RE: M-51 Industrial– Response to City Comments

Please refer to our responses below which address all review comments received from the City of Marysville on September 1, 2023, regarding the M-51 Industrial submittal package. You will find the markup comments listed in the order that they were written followed by our response in *italics*.

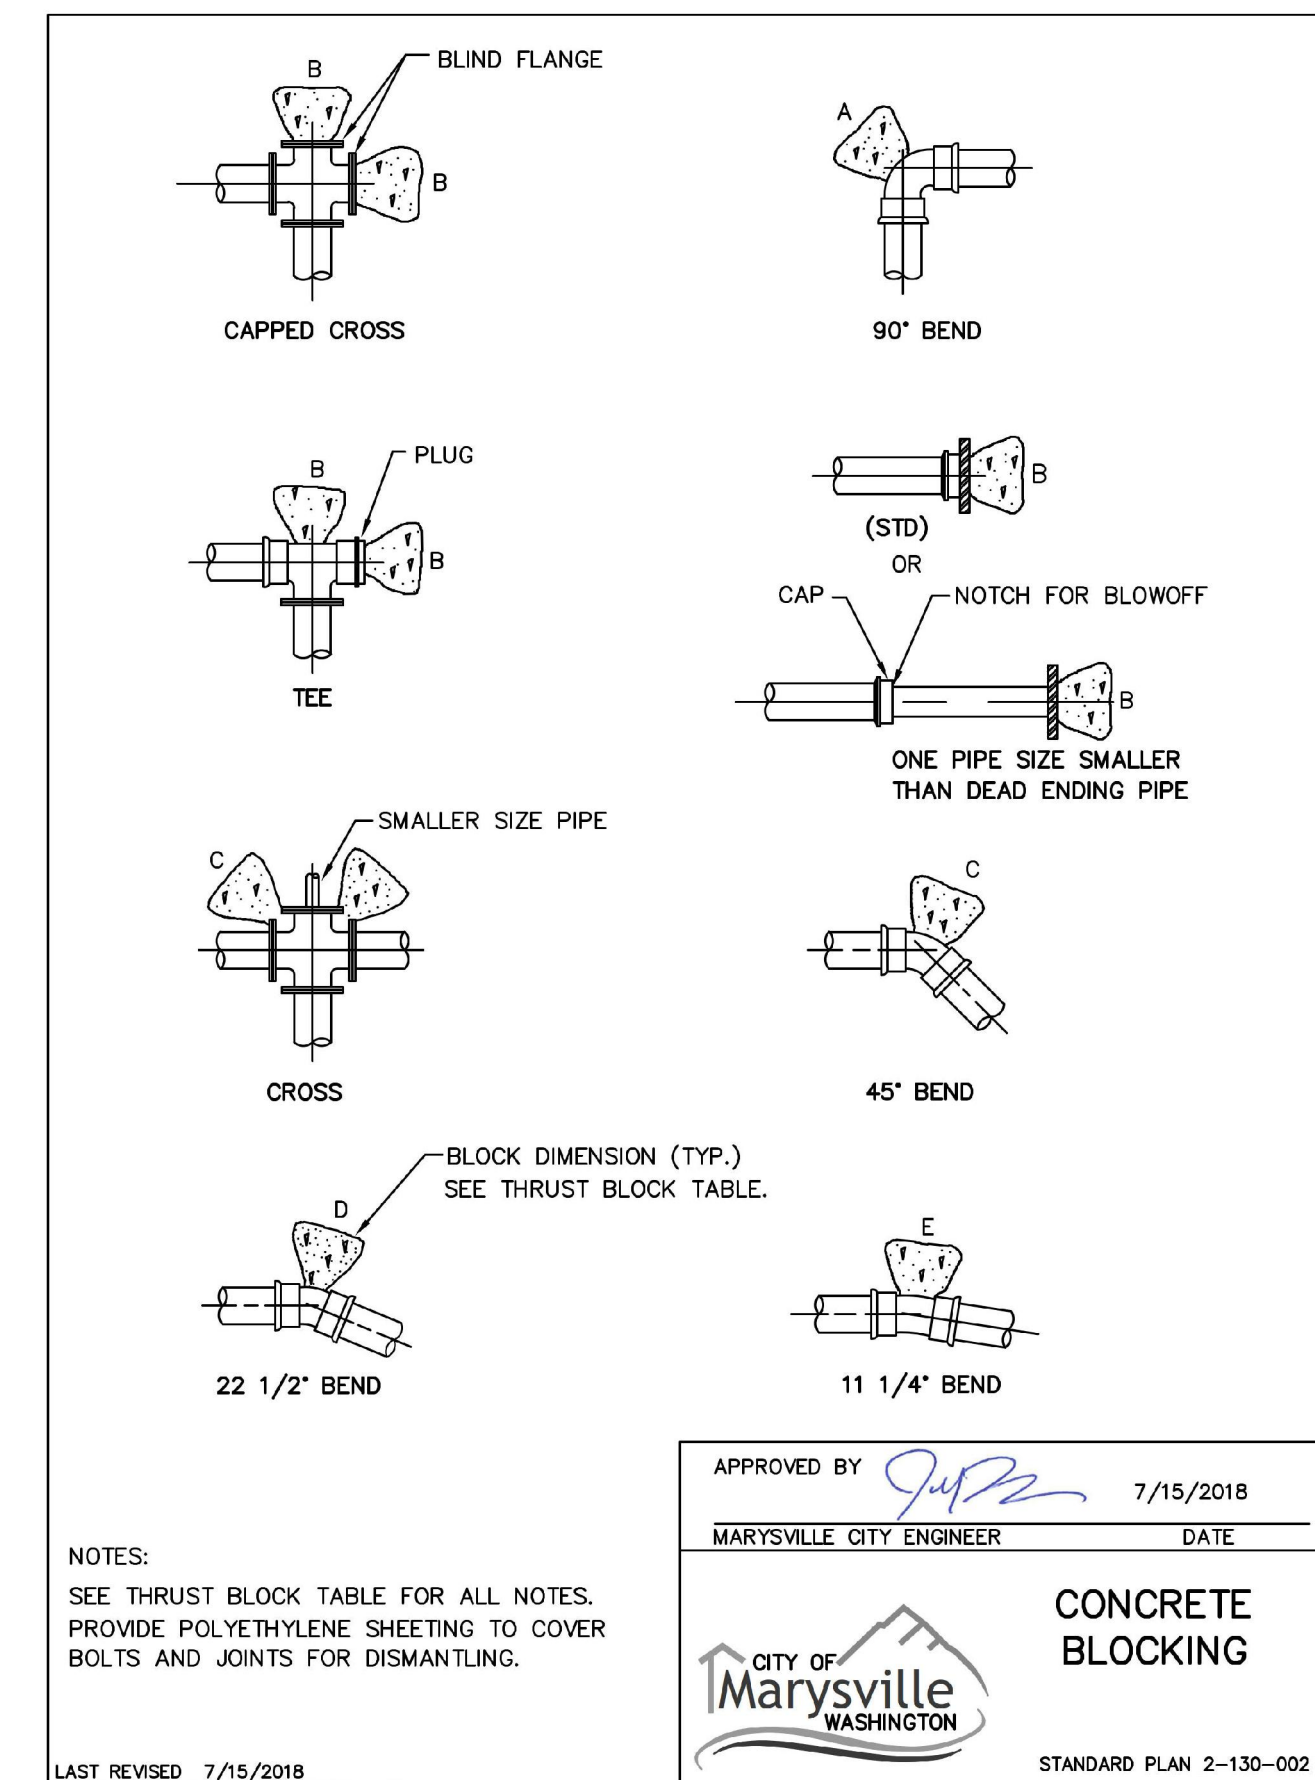
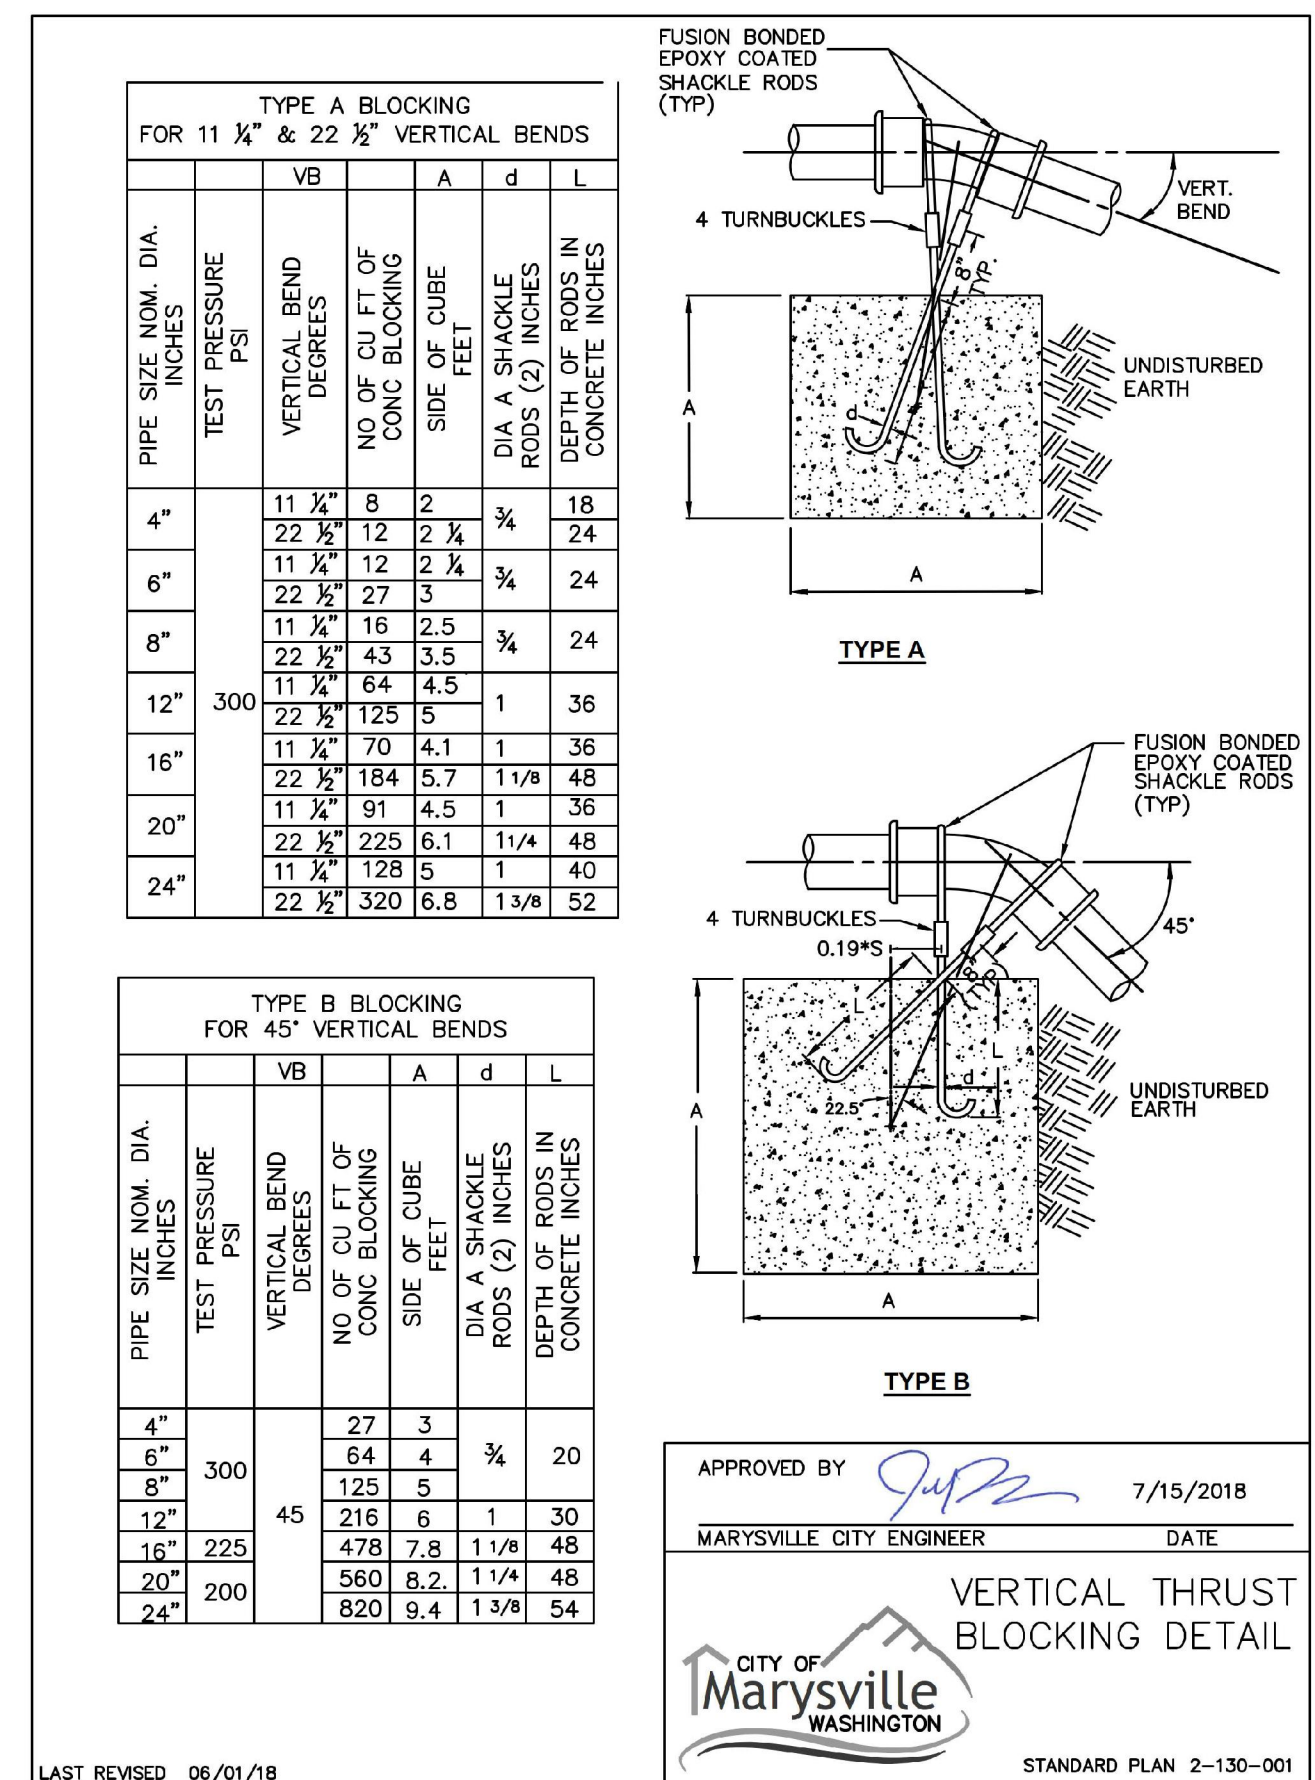
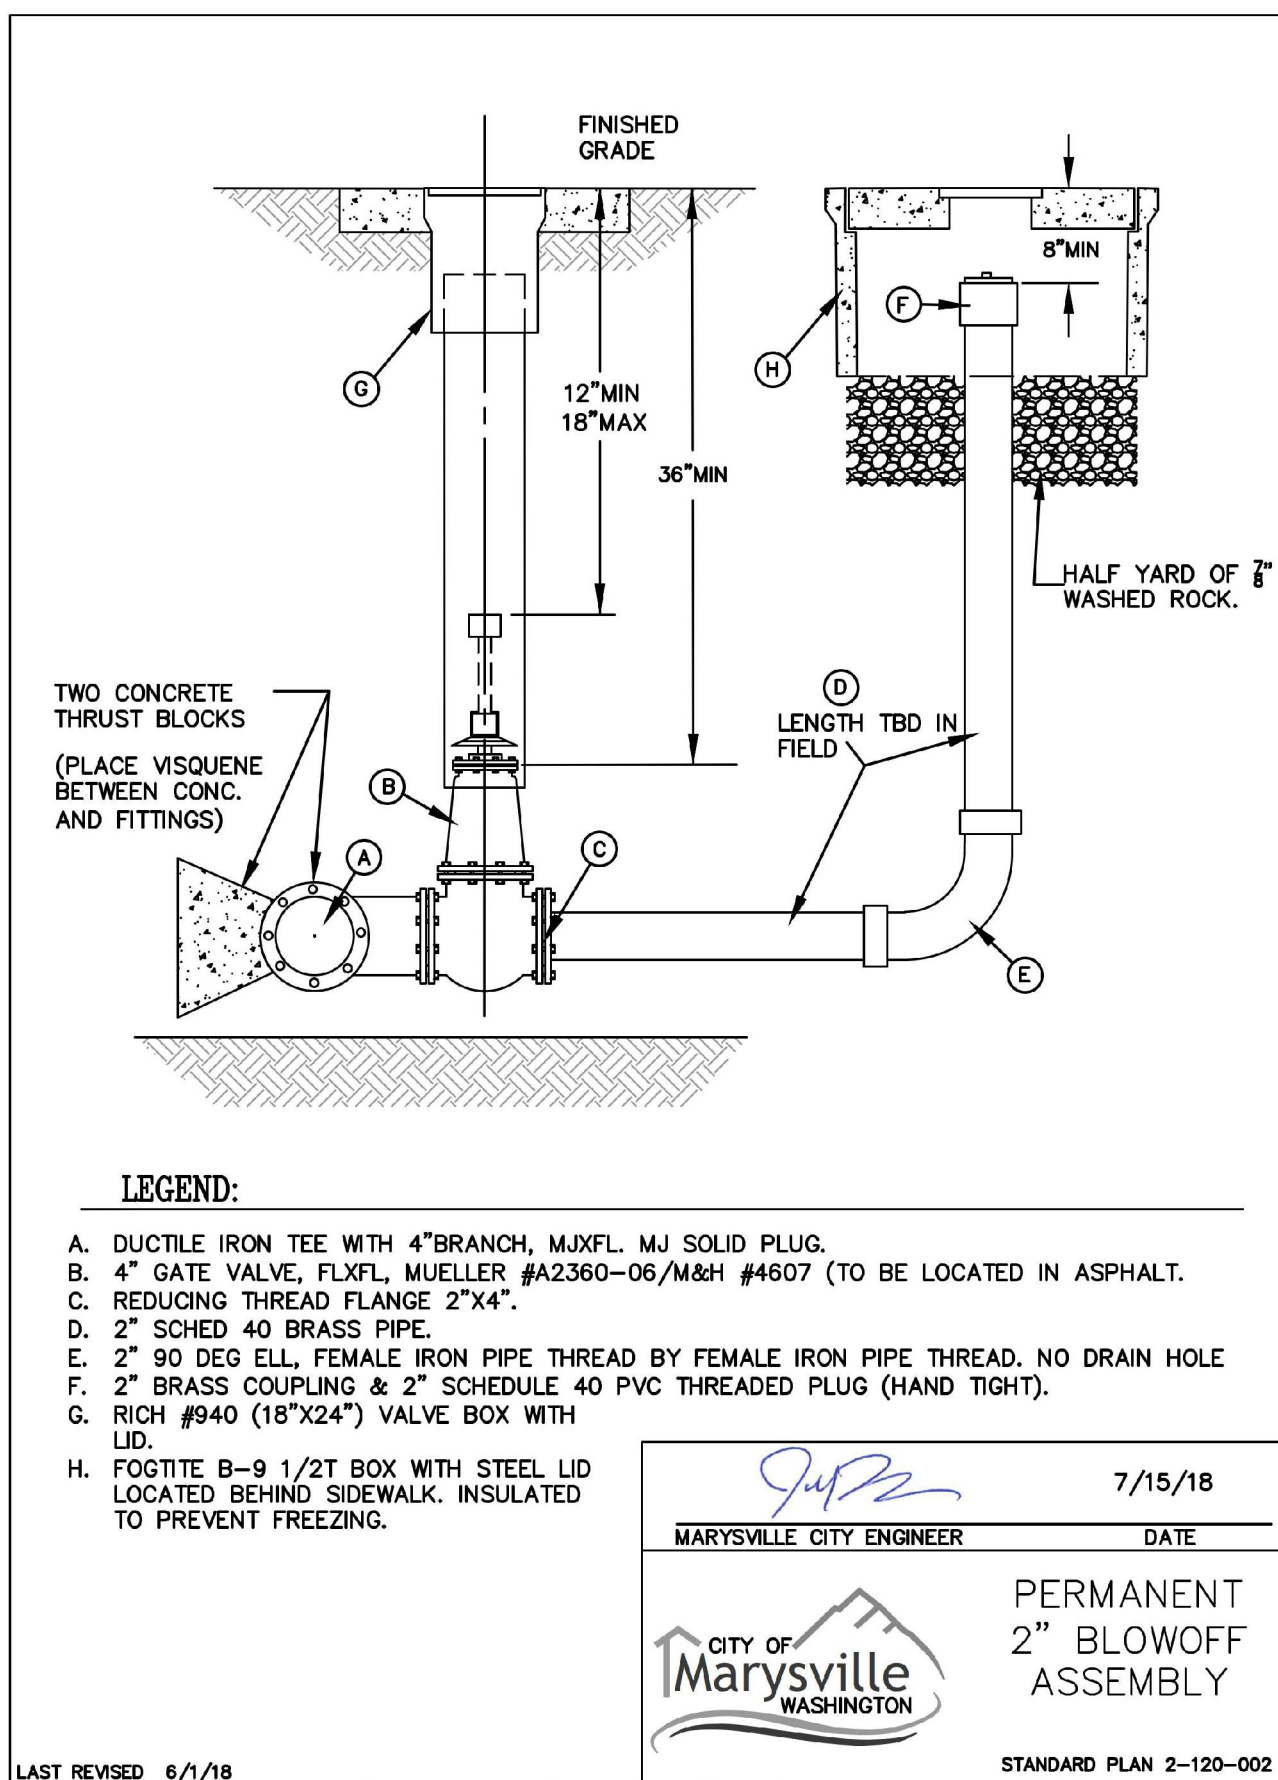
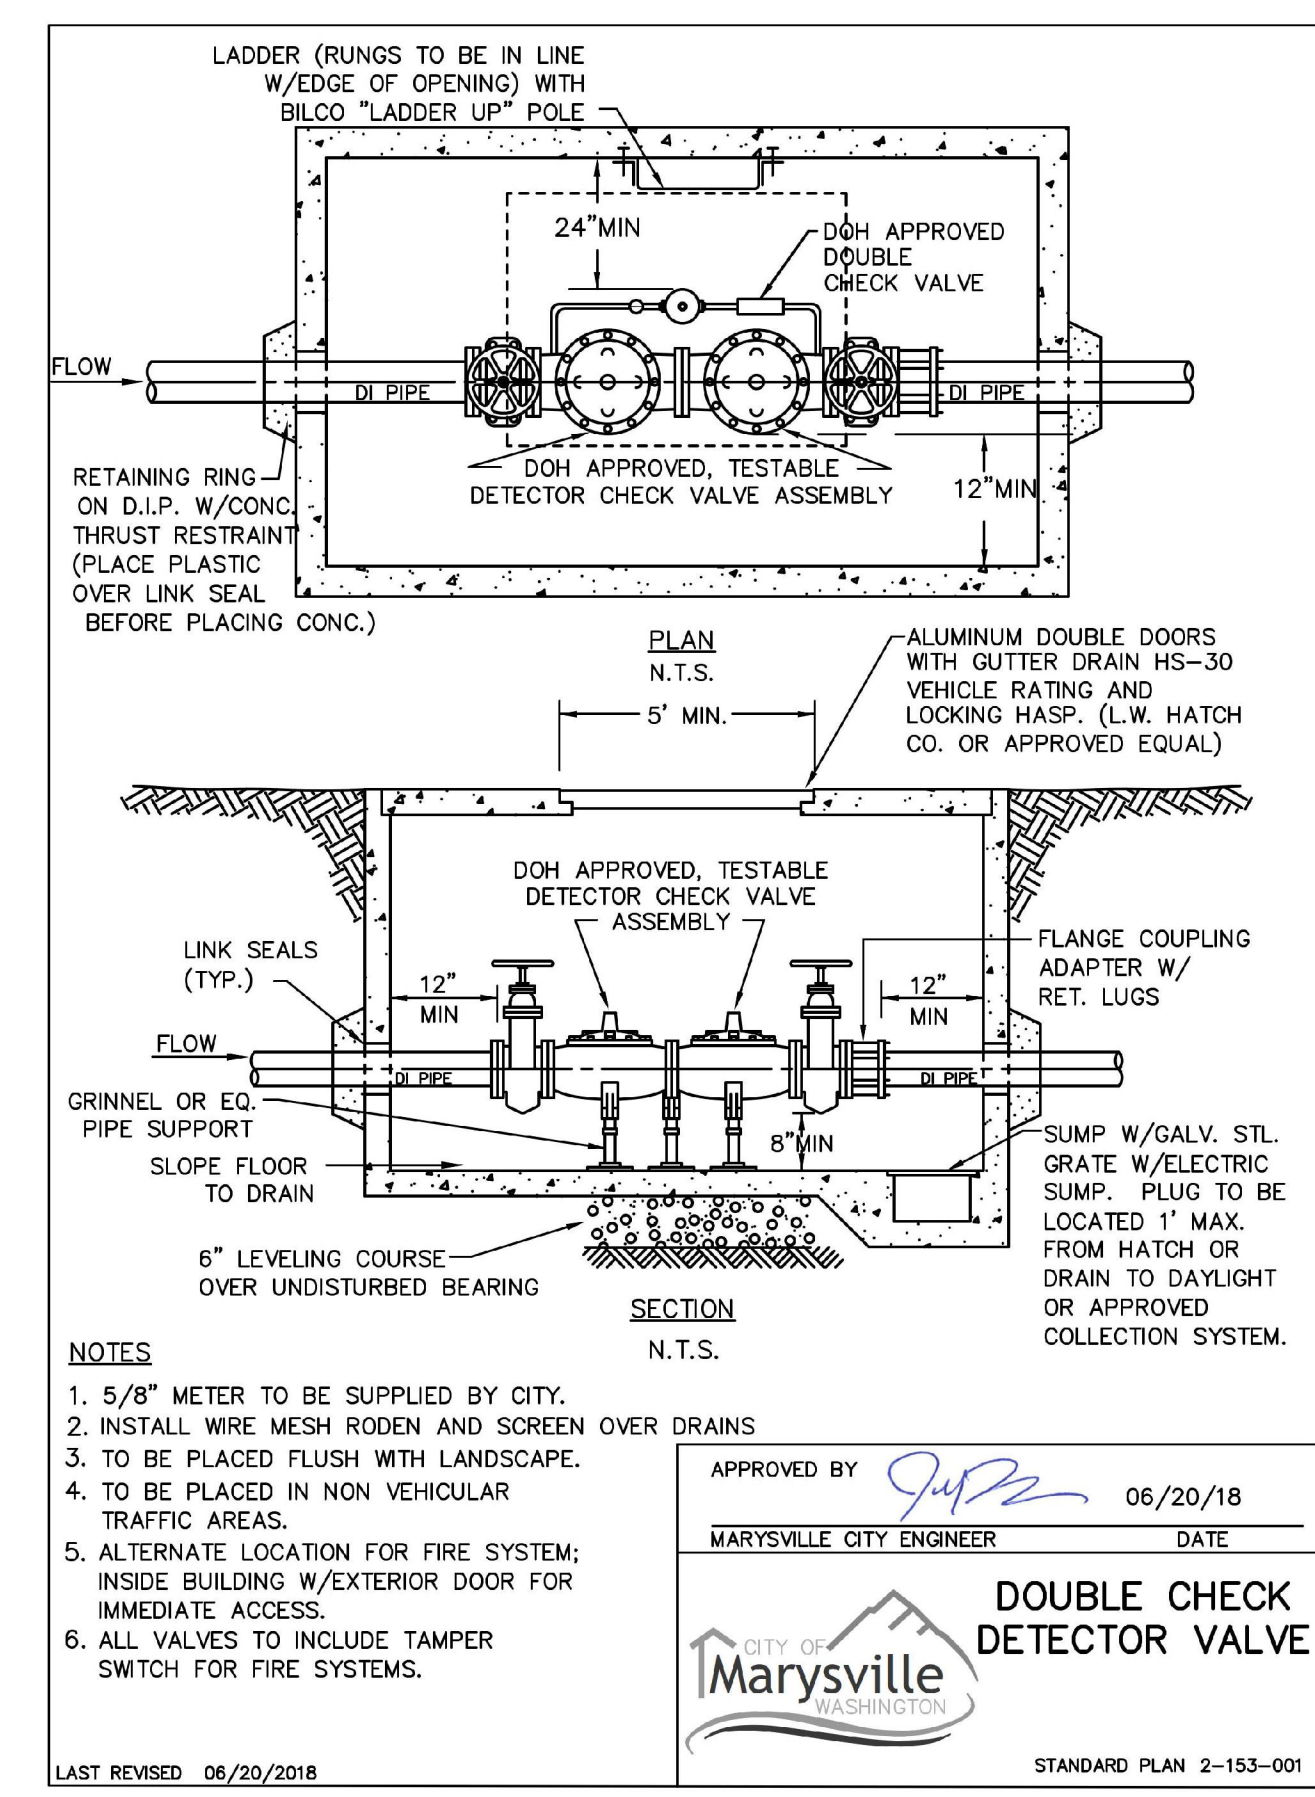
51. Water details not shown.

Response: Added water details to the plans.
